**Application for a non-material amendment following a grant of planning permission,  
Town and Country Planning Act 1990**

**Non Material Amendment on previous application 2016/91501 for erection of first  
floor side and rear extension, single storey rear extension and vehicular entrance  
gates (within a Conservation Area)**

**Braystone House, 32a, Wilshaw Road, Meltham, Holmfirth, HD9 4DZ**

**Application Number: 2016/93021**

title plans, location & site plan as proposed
number 16026D-01-P05
scale 1:50
size A1

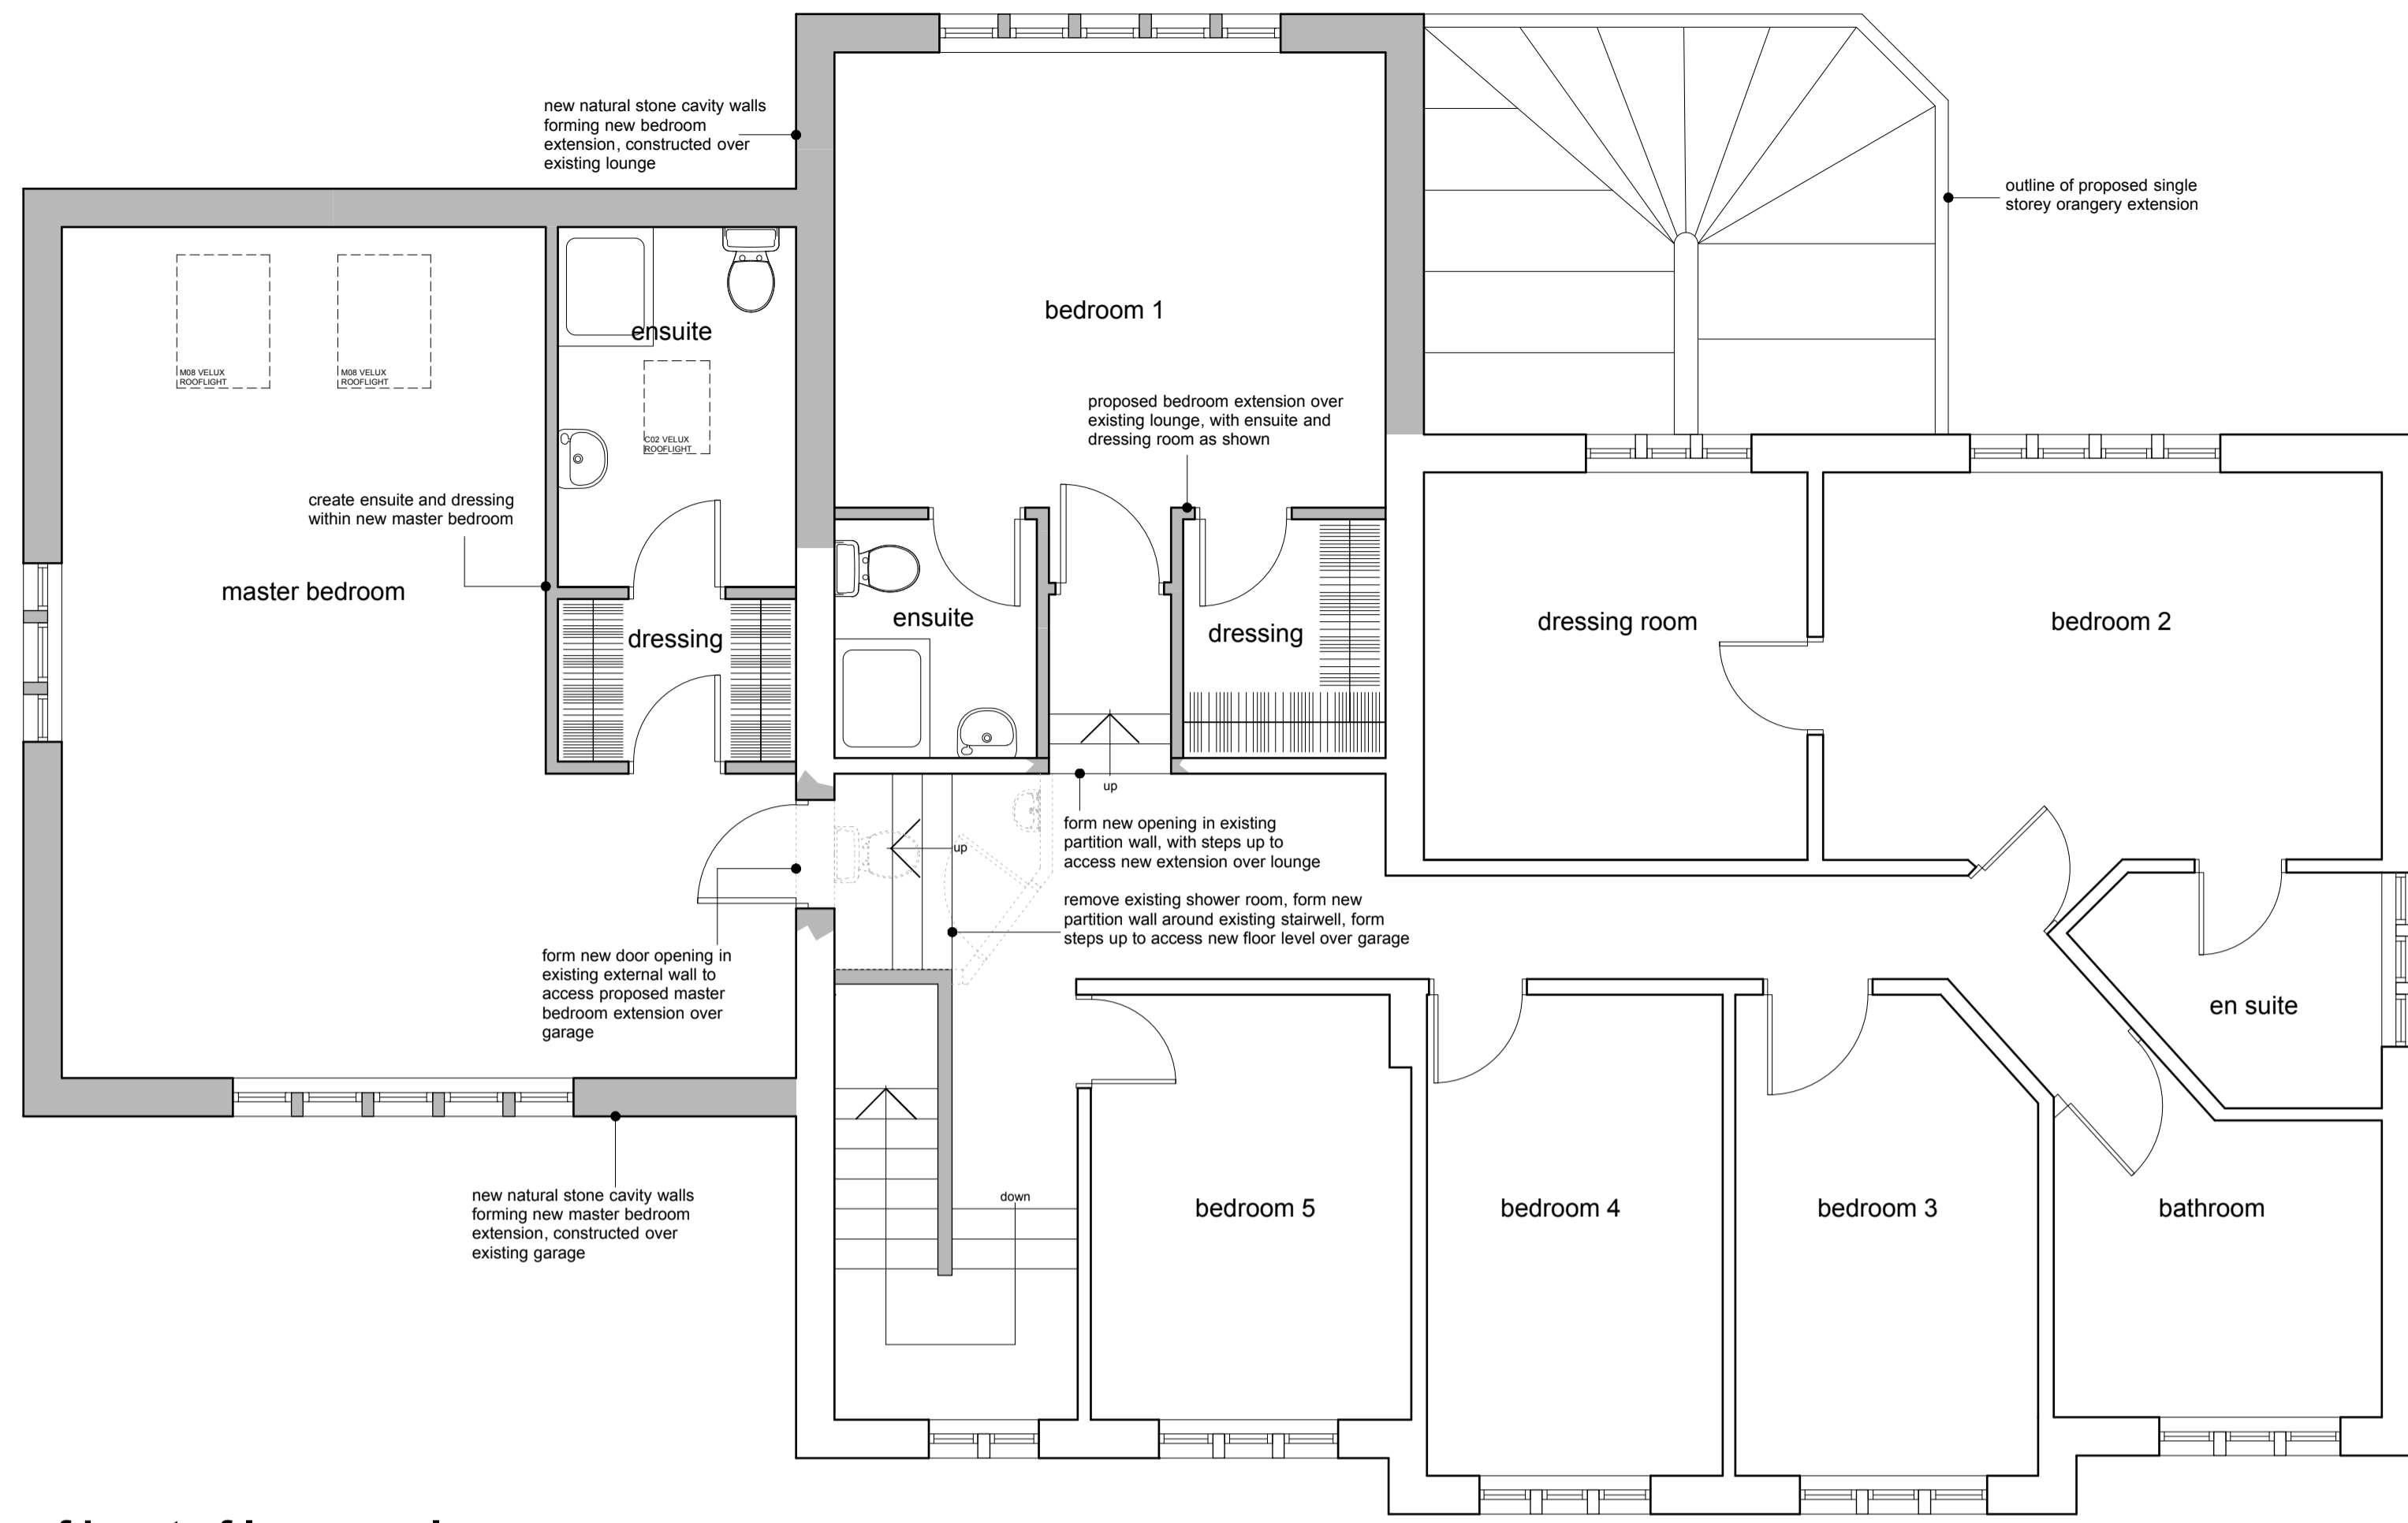
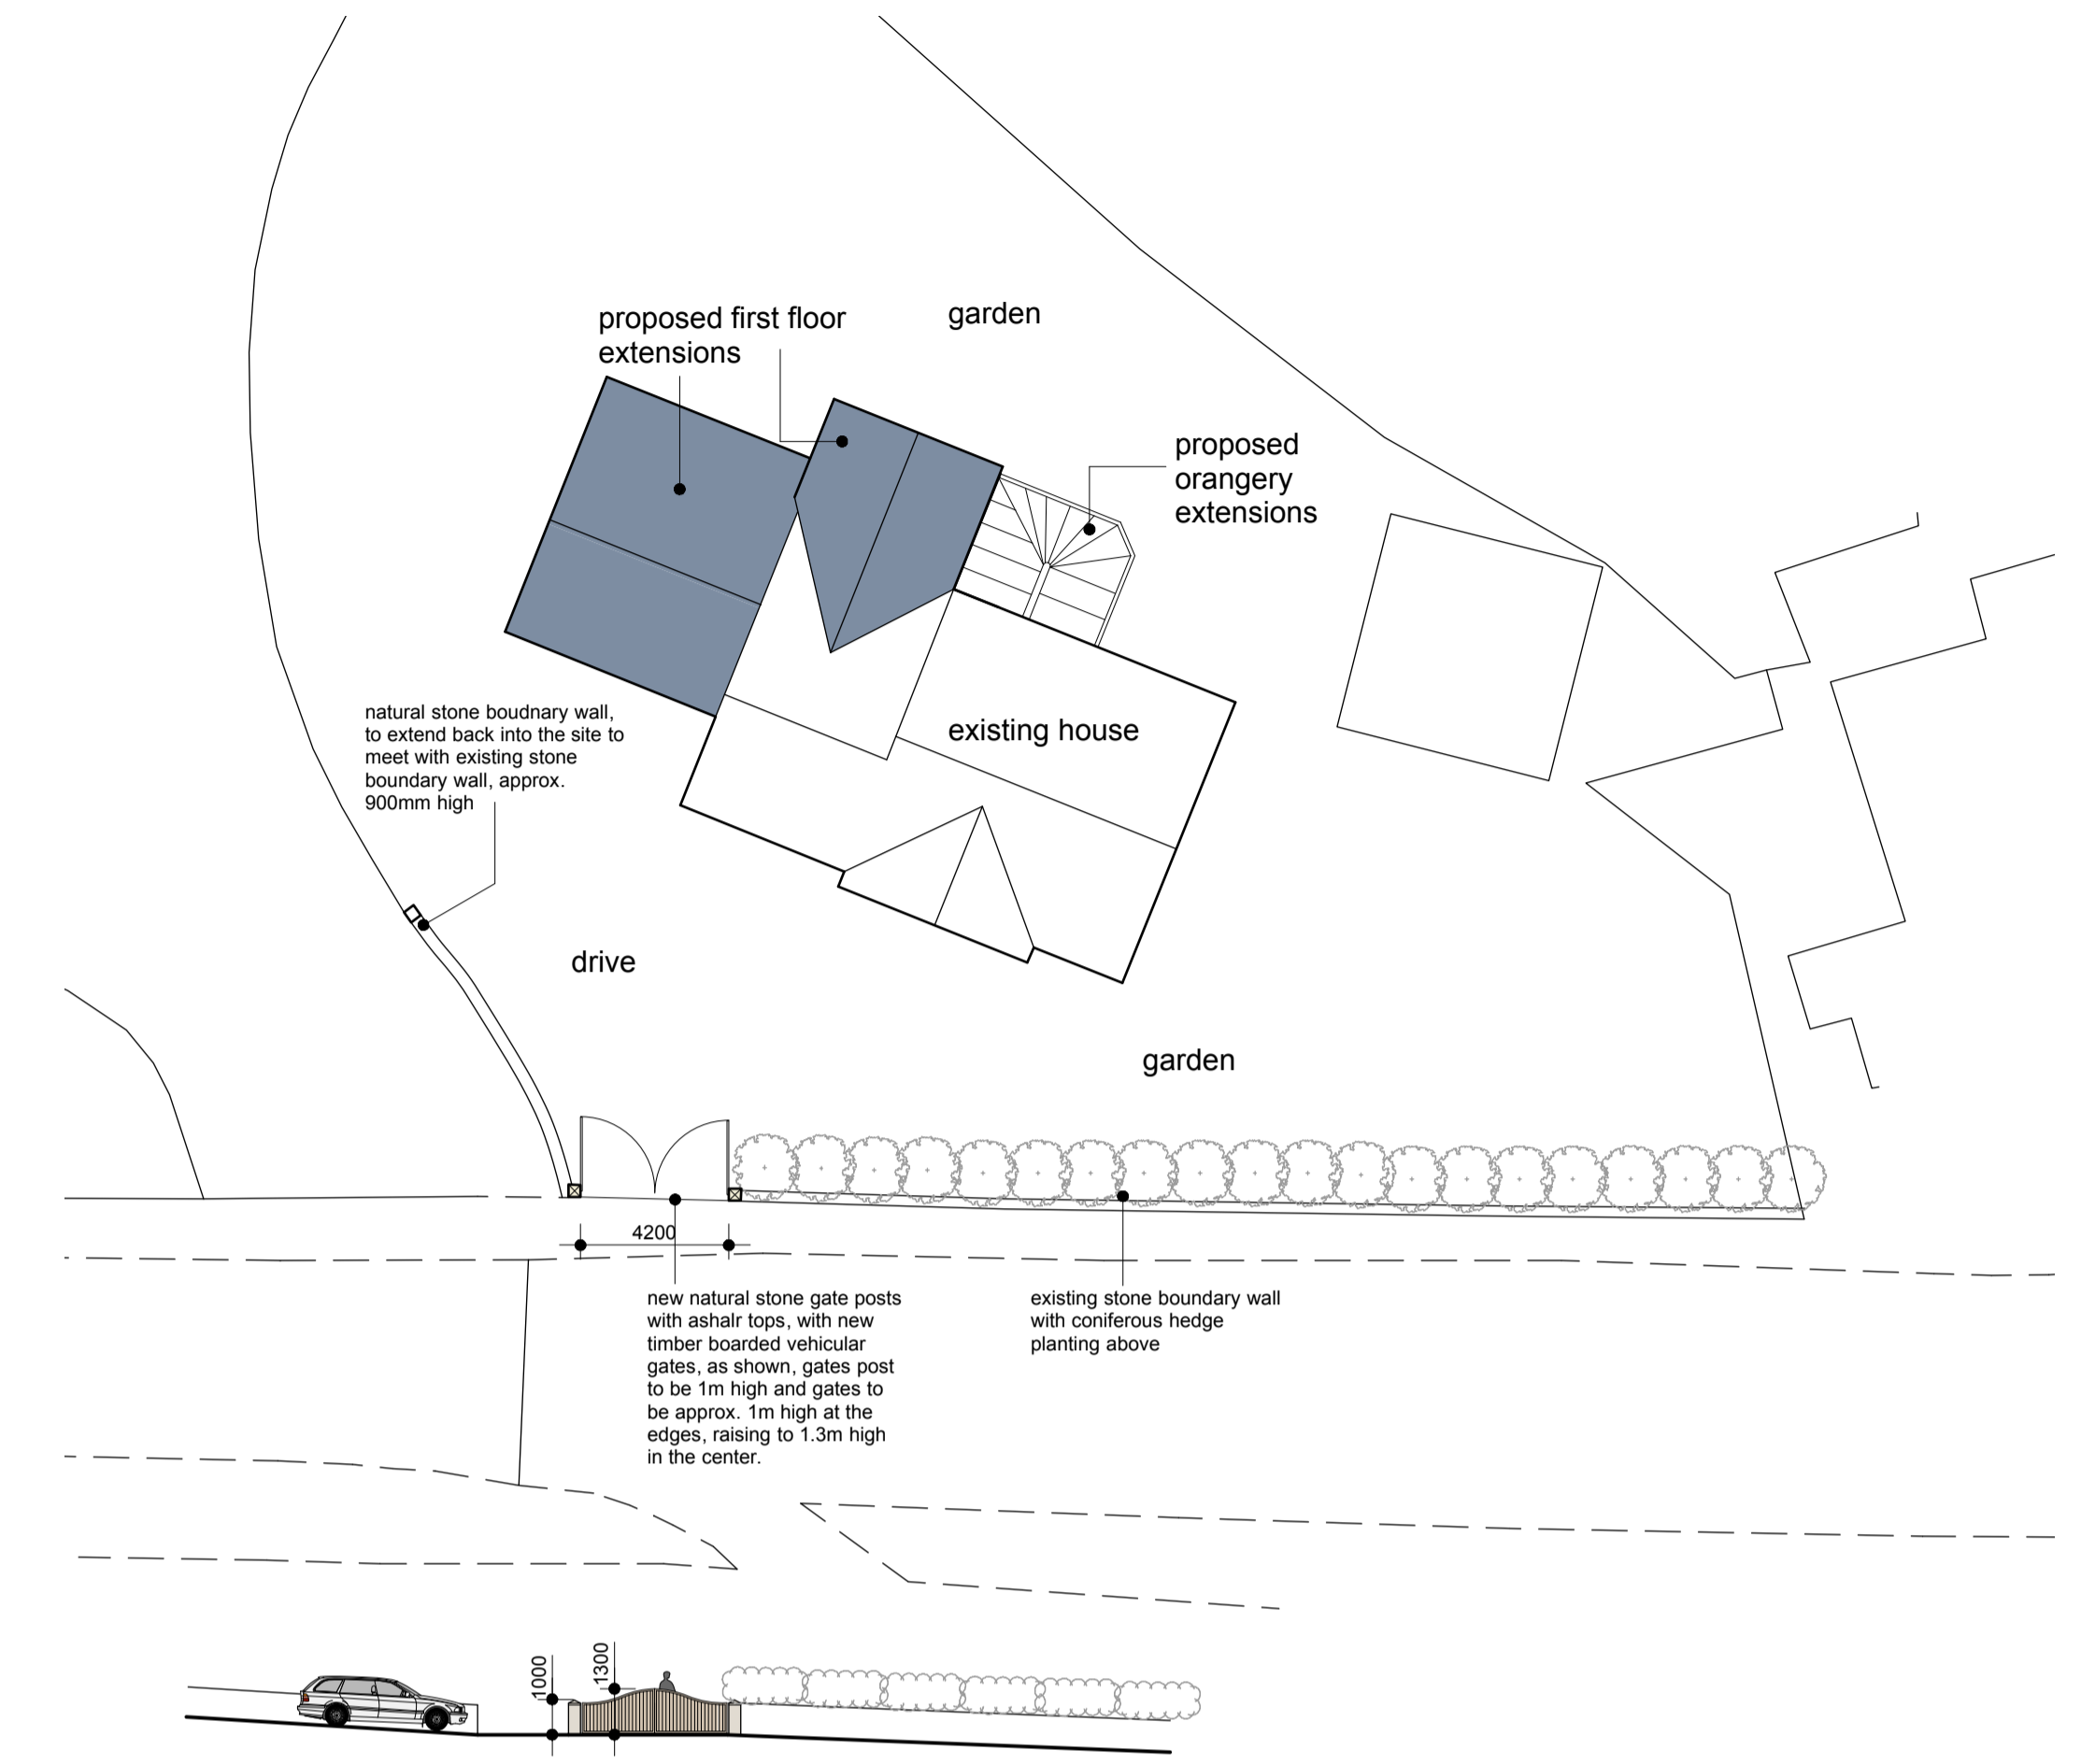
- Brick up the gaps in the ground floor support walls of the previously approved first floor side extension and erect a window and a door to enlarge the existing garage.
- Enlarge the previously approved rooflights.

These amendments are as indicated on drawing no's 16026D-01-P05 titled "plans, location & site plan as proposed" and drawing no. 16026D-02-P06 titled "elevations as proposed" received by the Local Planning Authority on 08 September 2016.

I confirm that the alterations are acceptable and may be considered as a non-material amendment to the approved drawings. It should be noted that this letter relates only to the non-material amendment sought and it is not a re-issue of the original planning permission. The two documents should be read together and as such, all conditions imposed on the original granting of planning permission apply to the proposal as now amended. A copy of this letter and the amended plans will be retained on the public record of approved documents.
